Re: Proposed 2 Storey Extension to Side.

At: 27 Manor Park, Silkstone, Barnsley. S75 4NE.

Application No: 2016 / 0341. Application Date: 29th. March 2016.

DRAWING No 824-01 REV A

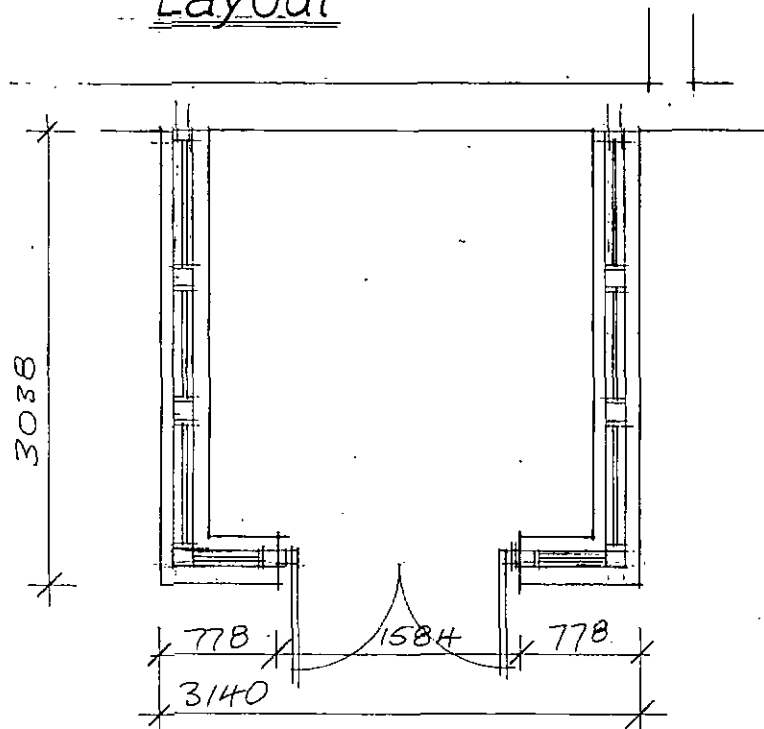
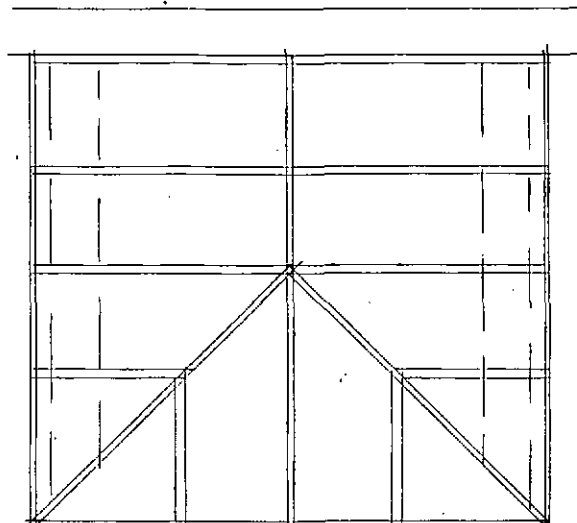
Further to your recent e-mail to ourselves concerning the above project and specifically your request to reduce the overall width of this side extension to 4050mm, please find attached single copies of information as listed below now amended hopefully to your requirements.

Also note the re-location of the proposed conservatory to the side as opposed to the rear – still ample amenity space provided.
